WEST SUSSEX COUNTY COUNCIL INFRASTRUCTURE CONSULTATION

SUBJECT: R/179/09

126 Sea Lane, Rustington

Amendments to planning permission R/283/07

BLOCK PLAN 1/500

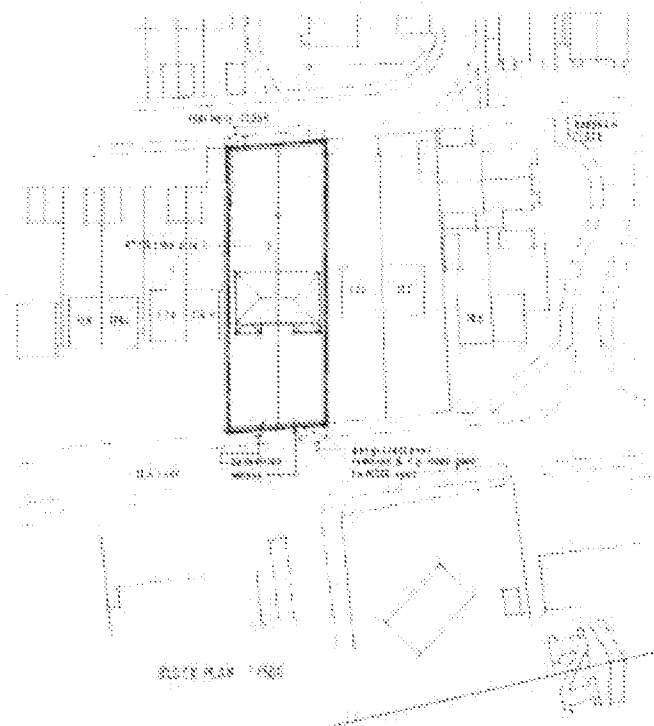
The proposal is a re-consultation under R/179/09. Under the previous consultation the highway authority requested that the on-site turning facilities were modified, and this application concerns that modification.

From an inspection of the plans alone, the revised parking and turning arrangement is a definite improvement upon the previous design. WSCC therefore has no further highway safety concerns regarding turning at this site.
